Gatwick Airport Northern Runway Project

Statement of Common Ground Between Gatwick Airport Limited and Crawley Borough Council

DATE: MARCH 2024

Application Document Ref: 10.1.1

Temporary Sussex Border Path Diversion

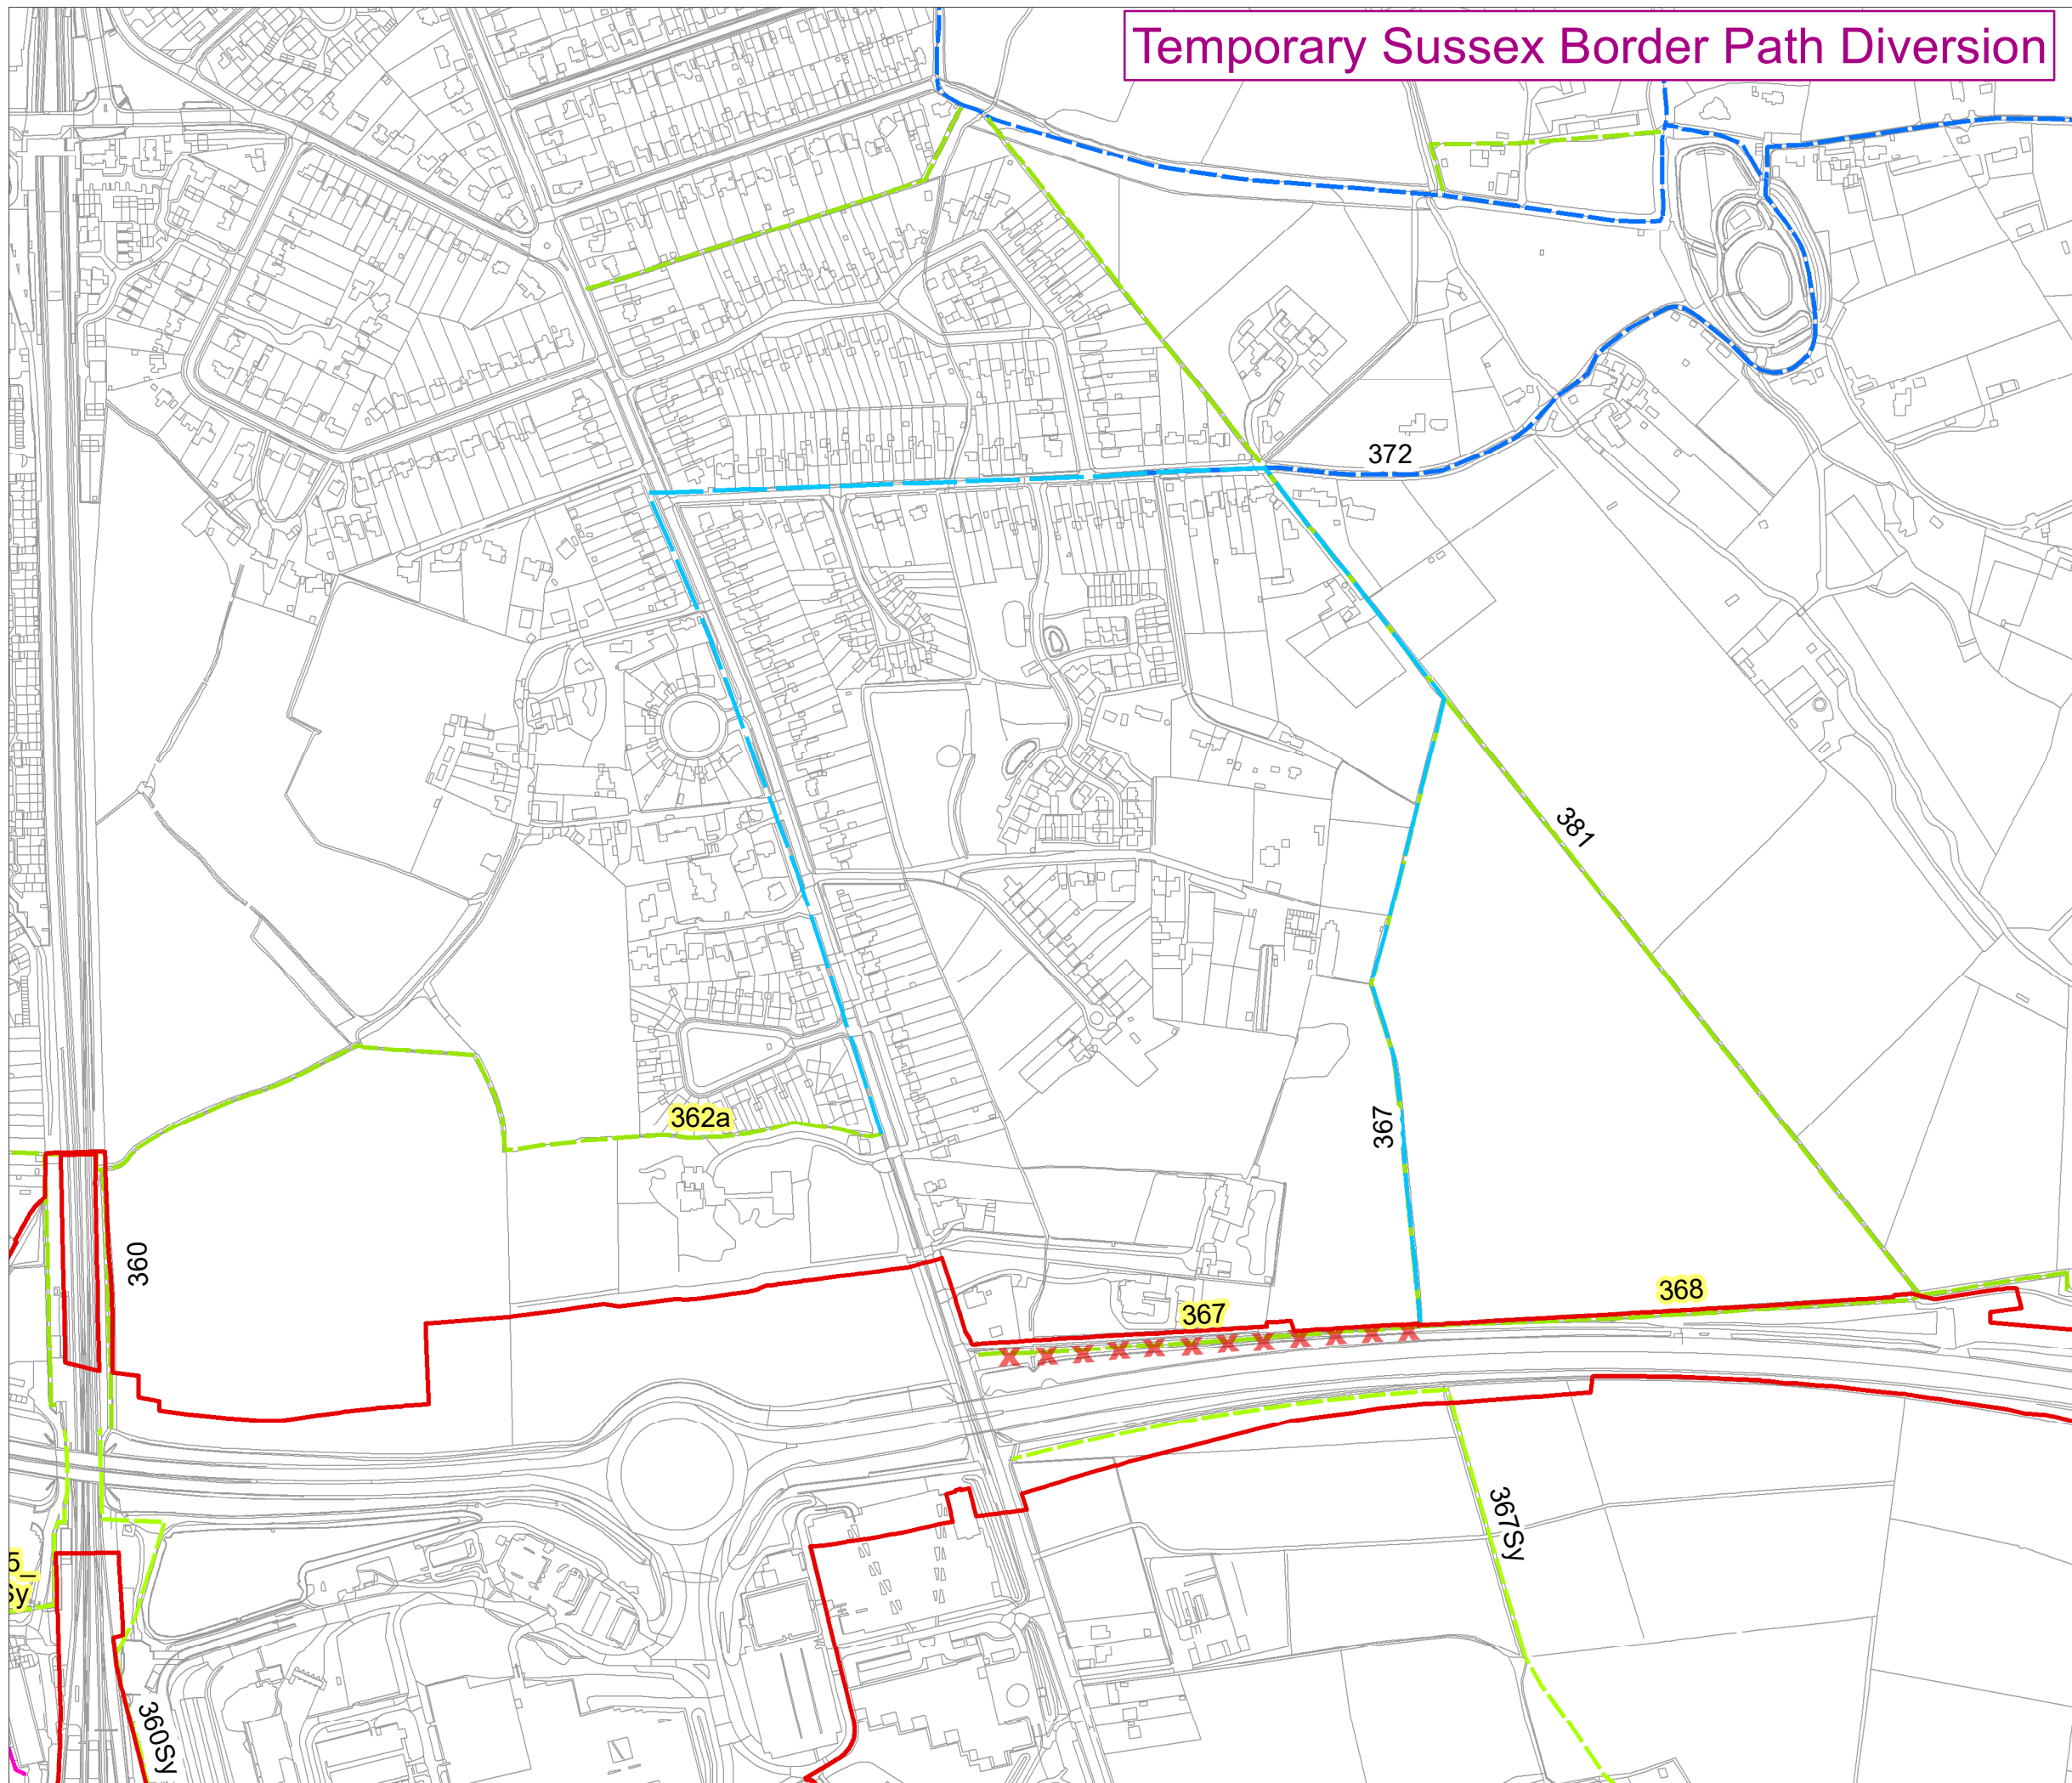
2.1.3.1	Quality of and impacts upon existing recreational routes affected by the DCO works during and post construction	<p>Lack of detail on the impacts on existing recreational routes as result of the works and the measures proposed to protect users (e.g., lorry routing, dust, damage to surfacing). Lack of detail or acknowledgement of potential opportunities to enhance and improve these routes for benefit of local community and for promotion of active travel.</p> <p>Updated position (Deadline 1): These paragraphs, if referenced from the Issues Tracker, refer principally to improvements around Riverside Gardens and replacement Sussex Border path as a direct consequence of the project works. CBC remains concerned about the impacts on other recreational routes. Refer to LIR for further detail.</p> <p>PROW strategy - needs further detail refer to LIR.</p>	<p>Substantial active travel infrastructure improvements are proposed as part of the surface access works for the scheme as summarised above and as illustrated in Figure 12.6.2 in the ES Traffic and Transport Figures and the Surface Access Highways Plans – General Arrangements. These proposals have been developed with due consideration of the guidance set out in LTN 1/20 and the relevant LCWIPs including the Reigate and Banstead LCWIP (May 2022) and Crawley LCWIP (2021) as well as due consideration of the site context, usage numbers, broader active travel connectivity and route corridors and environmental considerations.</p> <p>With respect to the proposed active travel path connection between Longbridge Roundabout, North Terminal Roundabout and South Terminal (located on the western side of A23 London Road), the proposed solution comprises predominantly segregated path provision between Longbridge Roundabout and North Terminal Roundabout (with the exception of over the A23 London Road River Mole bridge) and shared use provision between North Terminal Roundabout and South Terminal.</p> <p>Segregated provision north of North Terminal Roundabout was considered to be warranted for a number of reasons including anticipated relatively high volumes of pedestrians travelling on this route between Car Park Y and North Terminal.</p> <p>The proposals for surface access improvements reflect refinements made following consultation responses and engagement with National Highways and local highway authorities regarding junction layouts and active travel routes for pedestrians and cyclists. ES Chapter 5: Project Description, Section 5.2.109 describes the improvements to Longbridge Junction and the A23 London Road, including provision of Active Travel. The</p>	<p>Para 4.4.7 of ES Appendix 19.8.1 Public Rights of Way Management Strategy [APP-215]</p> <p>Paragraphs 19.6.28-19.6.42 of ES Chapter 19 Agricultural Land Use and Recreation [APP-044]</p> <p>Section 19.8 and Paragraphs 19.9.18 to Paragraph 19.9.32 of ES Chapter 19 Agricultural Land Use and Recreation [APP-044]</p> <p>Rights of Way and Access Plans – For Approval [APP-018]</p> <p>ES Traffic and Transport Figures [APP-059]</p> <p>Surface Access Highways Plans – General</p>	Under discussion

<p>Longbridge Roundabout layout is shown in the ES Appendix 5.2.1: Surface Access General Arrangement Plans.</p> <p>In respect of the Sussex Border Path, the proposed temporary diversions of PROW routes during construction have been developed to maintain safety for PROW users during construction. Additional details in relation to the management of temporary PROW diversions is set out in Section 4 of the Environmental Statement Appendix 19.8.1: Public Rights of Way Management Strategy. Further details in relation to the temporary diversion provisions will be developed in consultation with the local authorities through the construction stage post-DCO consent.</p> <p>A PROW management strategy document, secured as a Requirement in the Draft DCO has been produced as part of the ES at Appendix 19.8.1 Public Rights of Way Management Strategy. The strategy describes the approach to managing the impacts on PROW because of the construction and operation of the Project to reduce disruption to users (as far as possible).</p>	<p>Arrangements [APP-020]</p>
